**RE: Review Comment Responses / Flying Horse North
El Paso County, Colorado**

SM ROCHA LLC is pleased to provide comment response information for the proposed Flying Horse North sketch plan. This development is located along Old Stagecoach Road between State Highway 83 and Black Forest Road in El Paso County, Colorado.

The purpose of this letter is to respond to CDOT Staff review comments dated September 19, 2022 (1st Review). We have provided detailed responses to the review comments and made revisions to the Traffic Impact Study. We remain available to discuss further if needed.

The purpose of this letter is to respond to the Traffic Impact Study Reviews memorandum dated August 26, 2022 (2nd Review). We have provided detailed responses to the review comments and made revisions to the Traffic Impact Study. We remain available to discuss further if needed.

Figure 13
TOTAL TRAFFIC - YEAR 2042
 Intersection Geometry

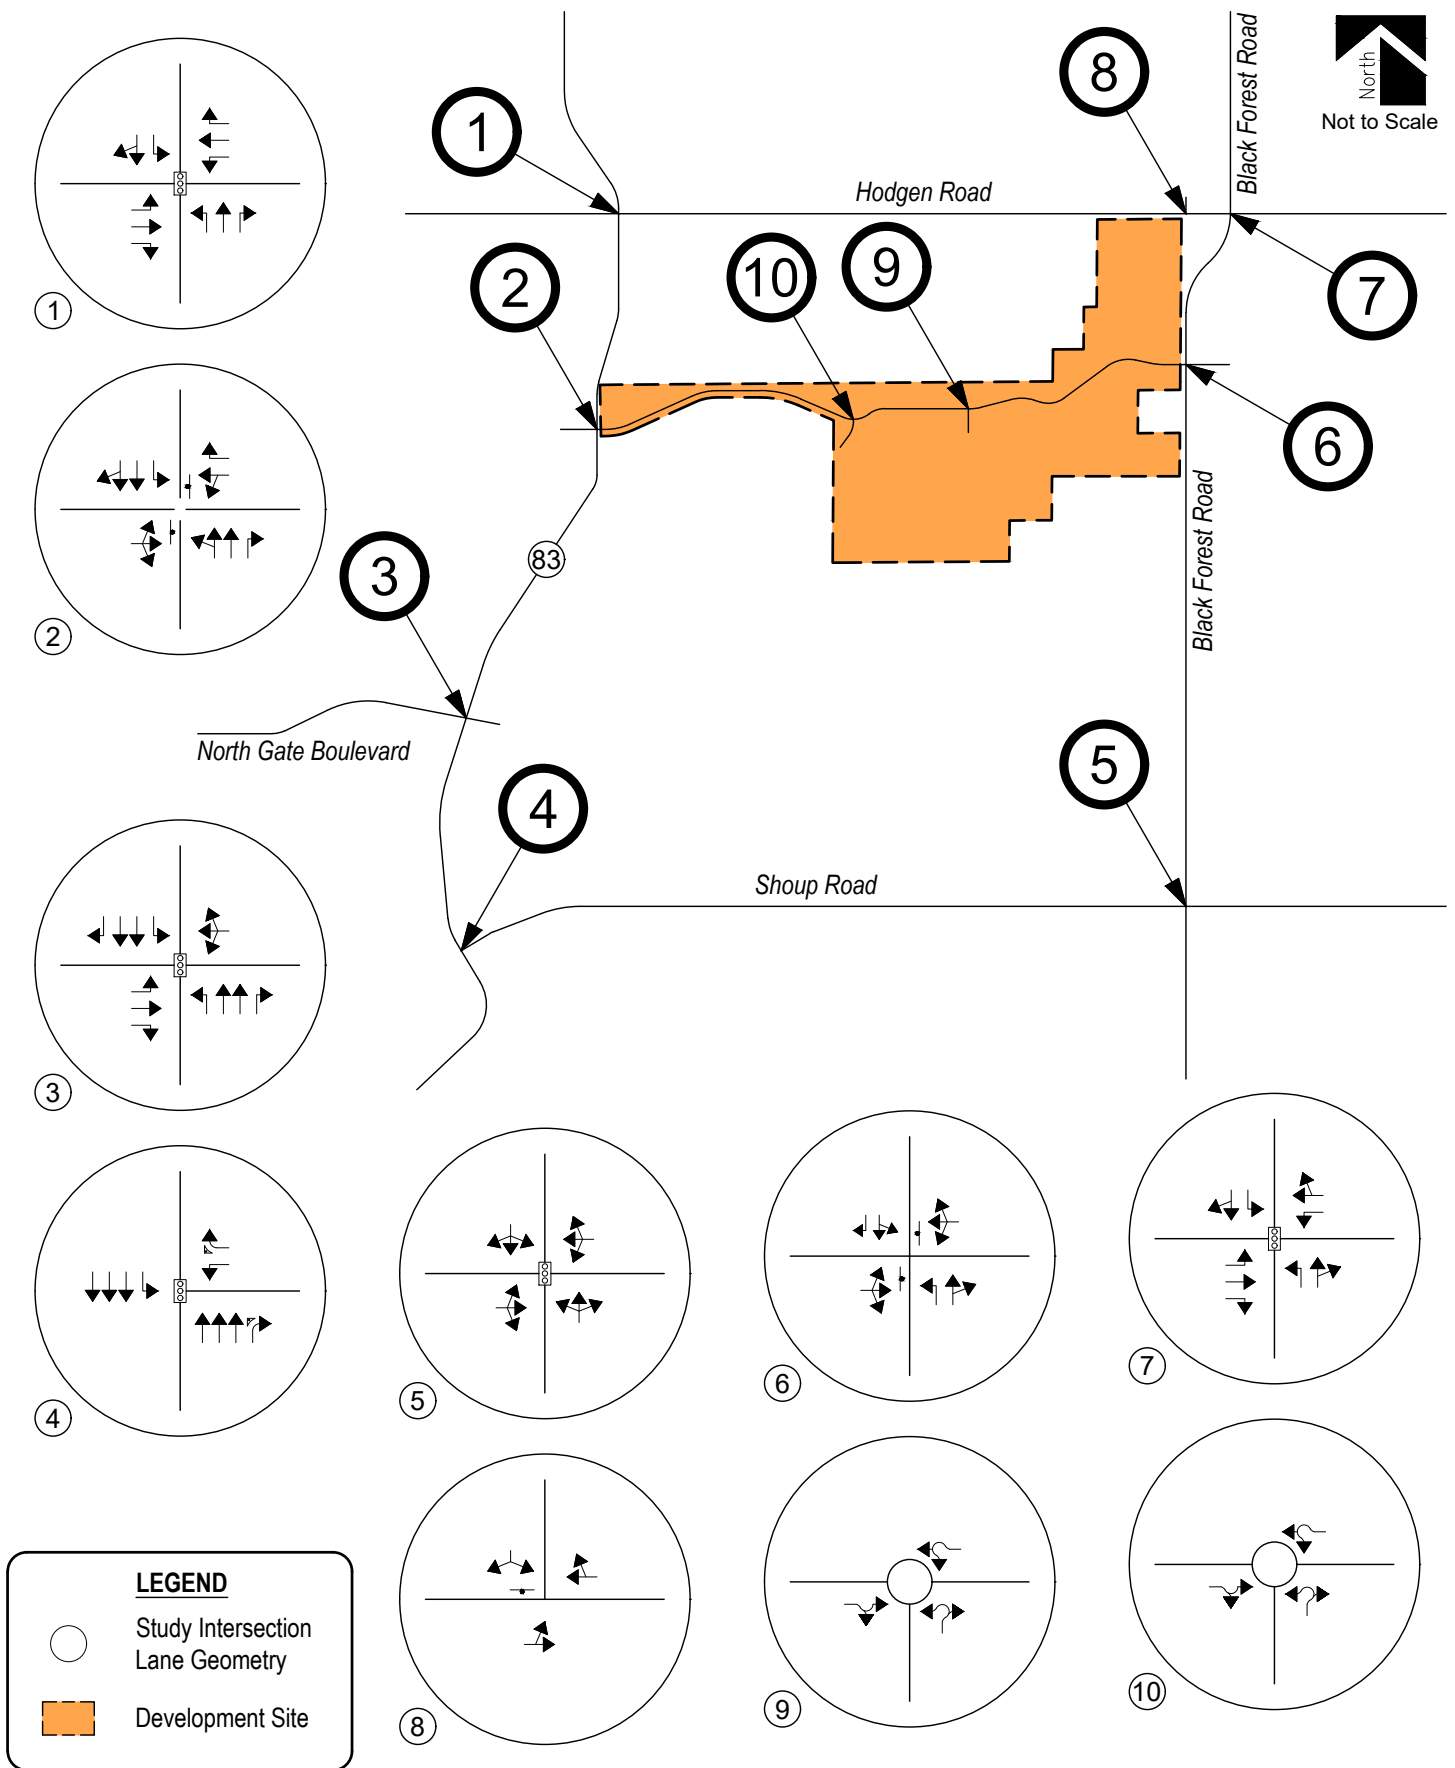
TIS Review Comment 1: The project generates 26,500 daily trips with approximately 70% of the trips accessing SH83 at Stagecoach. This location is planned for full movement access.

TIS Review Comment 2: Over the last five years the section of highway approaching Stagecoach and the intersection itself has seen an increase in traffic crashes including a fatality. The TIS indicates that signal warrants are met with the project traffic added. The PM peak would exceed capacity if signalized and require double lefts for the WB to SB direction. This in turn would require additional receiving lanes on SH83. Traffic signals are not always the most appropriate intersection control. The analysis indicates that in 2027, the roundabout functions much better with single receiving lanes and the existing approach lane configuration. Roundabouts have a much higher safety record than traffic signals resulting in about a 70% reduction in predicted crashes. Furthermore, the implementation of a roundabout at this location would help to control travel speed through this immediate area.

TIS Review Comment 3: As part of the access permit offer, CDOT will require the design and construction of a roundabout to facilitate site access at the intersection of SH83 & Stagecoach. The TIS should be modified to accommodate this requirement.

Comment Response: Analysis for roundabout control at State Highway 83 and Stagecoach Road will be included with the revised traffic study.

If signalization is pursued, analysis does not indicate the need for dual westbound left turn lanes, but rather one exclusive turn lane and analysis assumes shared left and through lane.

Comment Response: Comment acknowledged. Traffic study now considers roundabout-control as the preferred condition for total traffic conditions.
